CITY OF ALBUQUERQUE

**RE: Mesa Del Sol Artiste
TRS 1-16, BULK LAND PLAT TRACTS 1 THROUGH 18 ARTISTE
Drainage Report
Engineer's Stamp Date: 7/3/2025
Hydrology File: R15D003A
Case #: HYDR-2025-00239**

Based upon the information provided in your submittal received 7/3/2025, the Drainage Report is **not** approved for Grading Permit, preliminary plat approval and work order approvals. The following comments need to be addressed for approval of the above referenced project:

**EXHIBIT A:
PRELIMINARY PLAT**

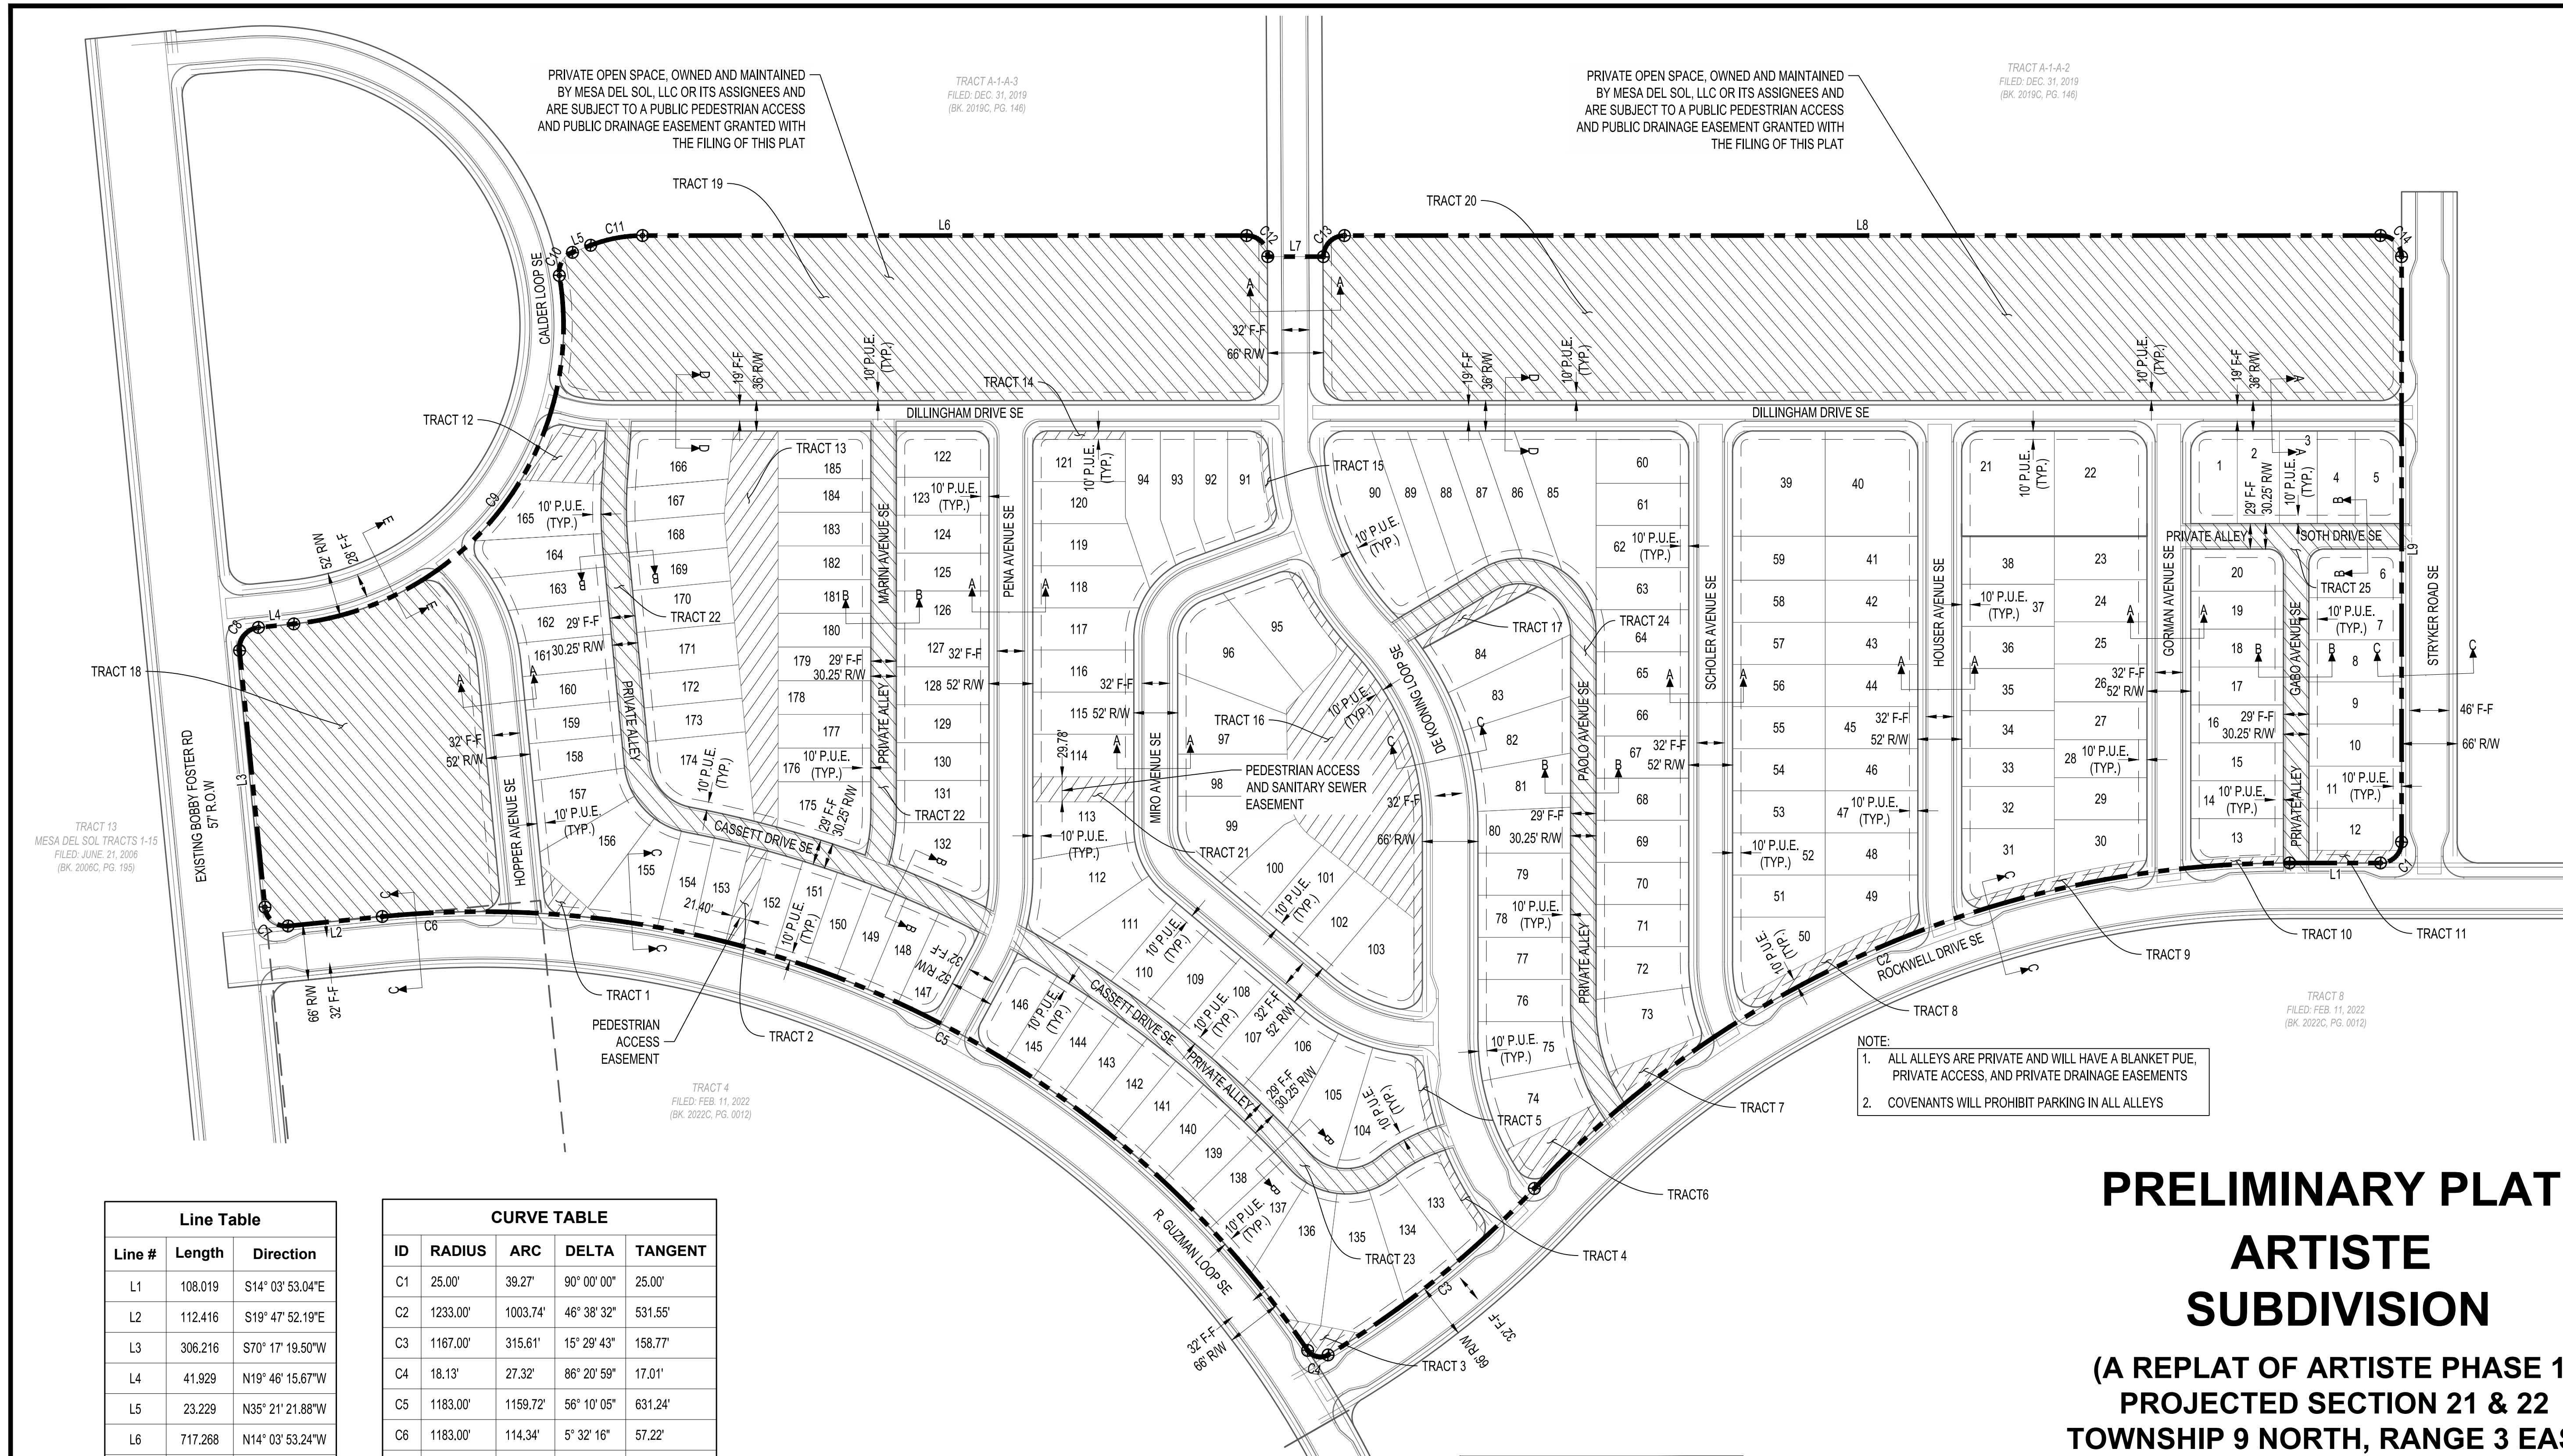
1. Please add a vicinity map with the Zone Atlas number and the FEMA FIRM map and floodplain note with effective date on Exhibit A.
2. Page 12, proposed conditions, basins 9 & 10 have 88 & 78 units respectively. But on Exhibit C, they are 96 & 93 units. Other column values are changed due to these discrepancies. Please verify.
3. The "Storm Drain Pipe Table" on page 36 and on Exhibit D don't match. The pipe capacities for SDP16, SDP38 & SDP39 on Exhibit D are less than the actual flow rate. Are there any specific reasons for that?
